MECKLENBURG COUNTY
Park and Recreation Department

MEMORANDUM

RE: Rezoning Petition # 2008-060 Gale Property (Dixon Branch)

RZ-2.0

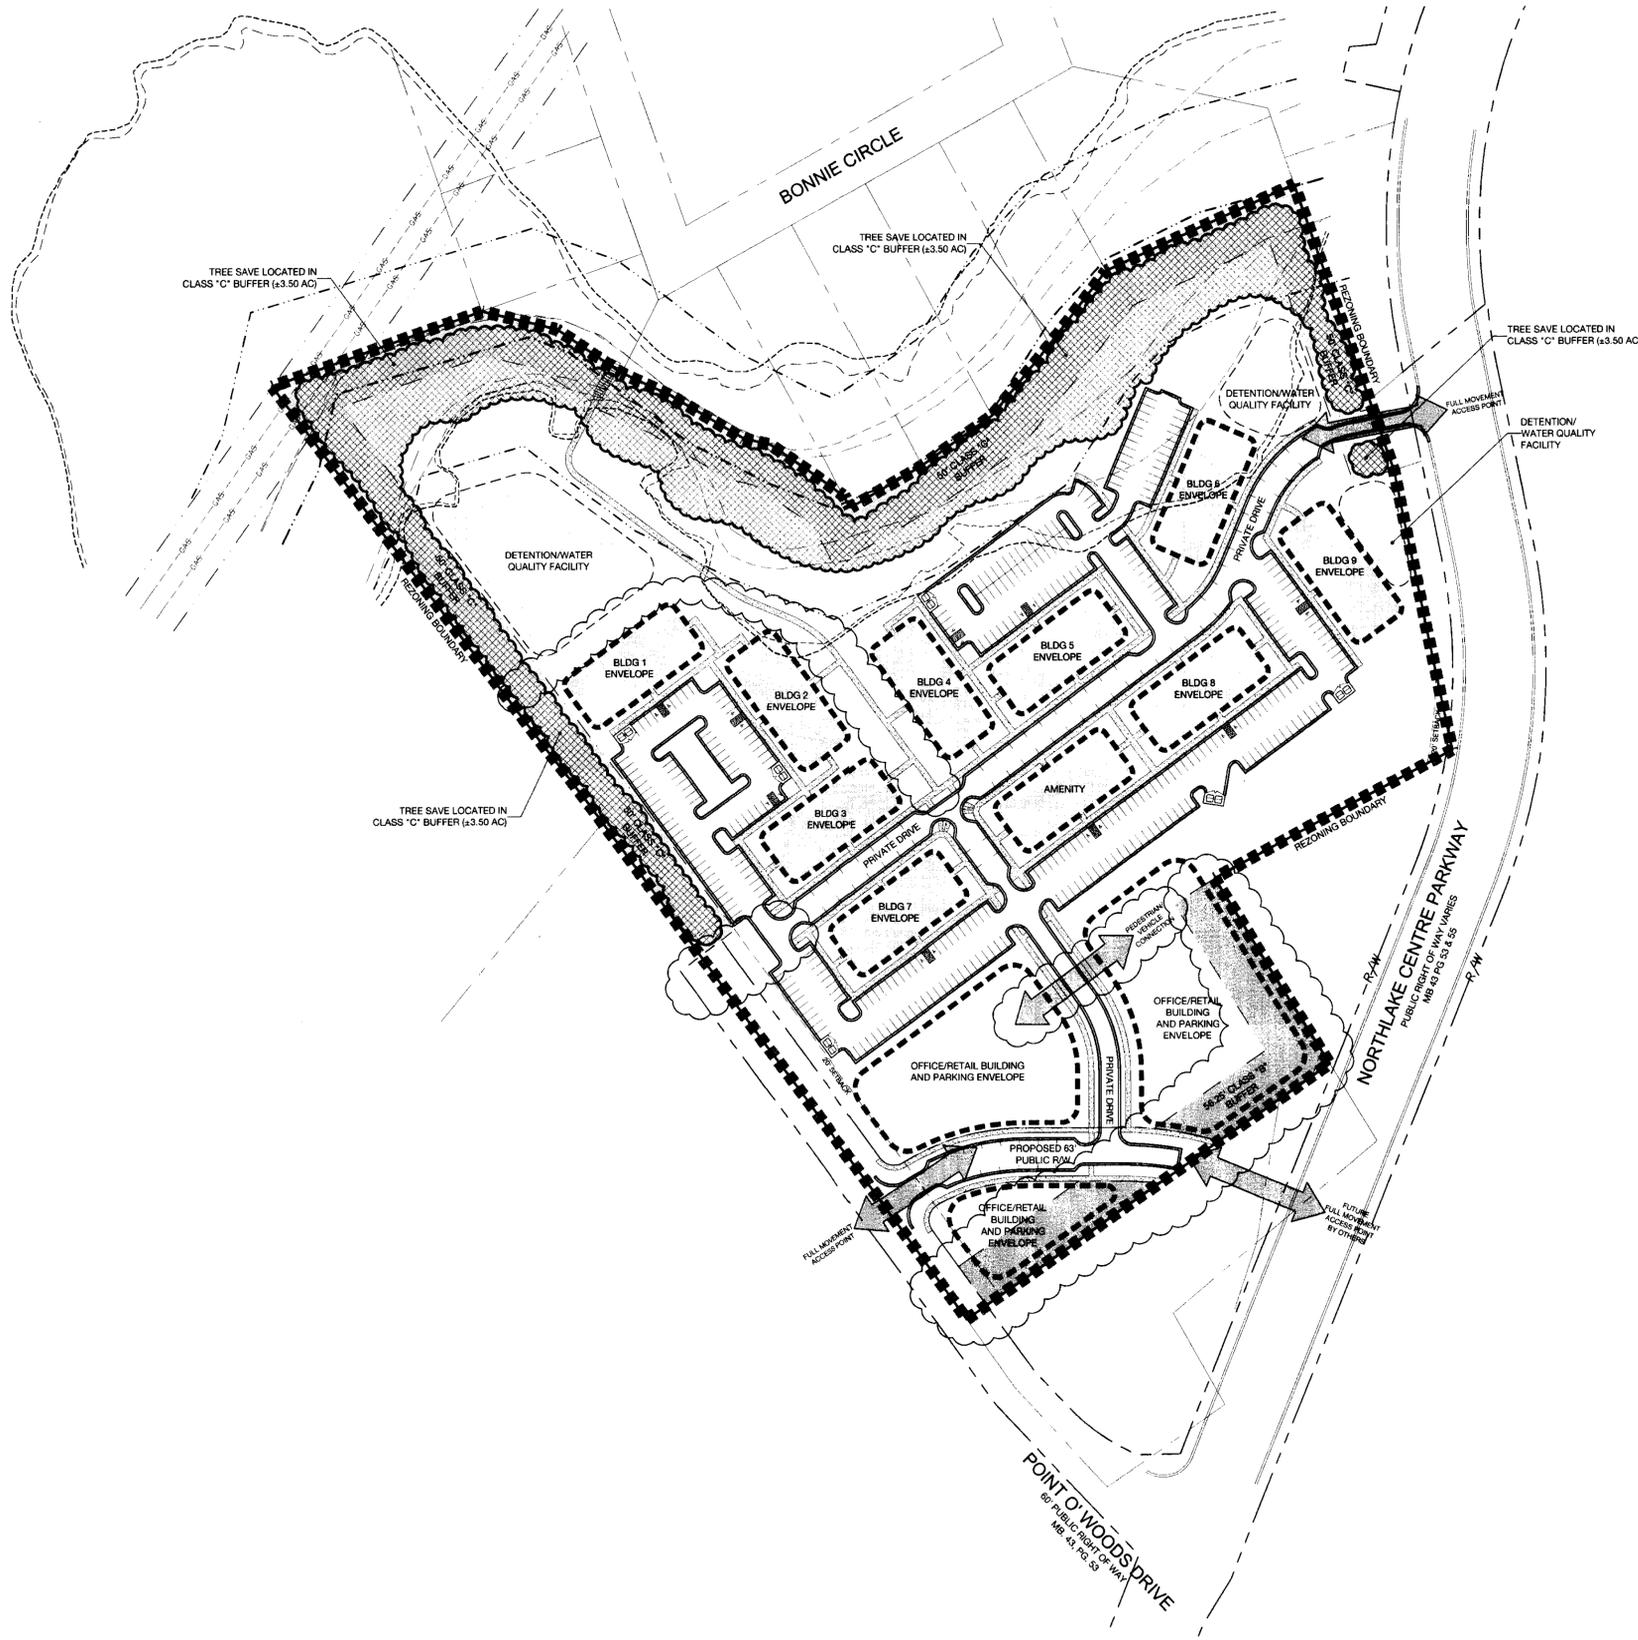
Therefore, MCPR requests dedication of the 100-year floodplain and 100-foot SWIM Buffer to the County for greenway and floodplain/watershed protection purposes. The site plan shows a general location of the proposed street network. Dedication of the floodplain appears to also be able to provide a greenway connection to one of the interior public streets, but the specifics are not shown at this time. MCPR requests the condition that there will be at least one (1) neighborhood connection shown as part of the dedication, which should be at least 40-feet in width.
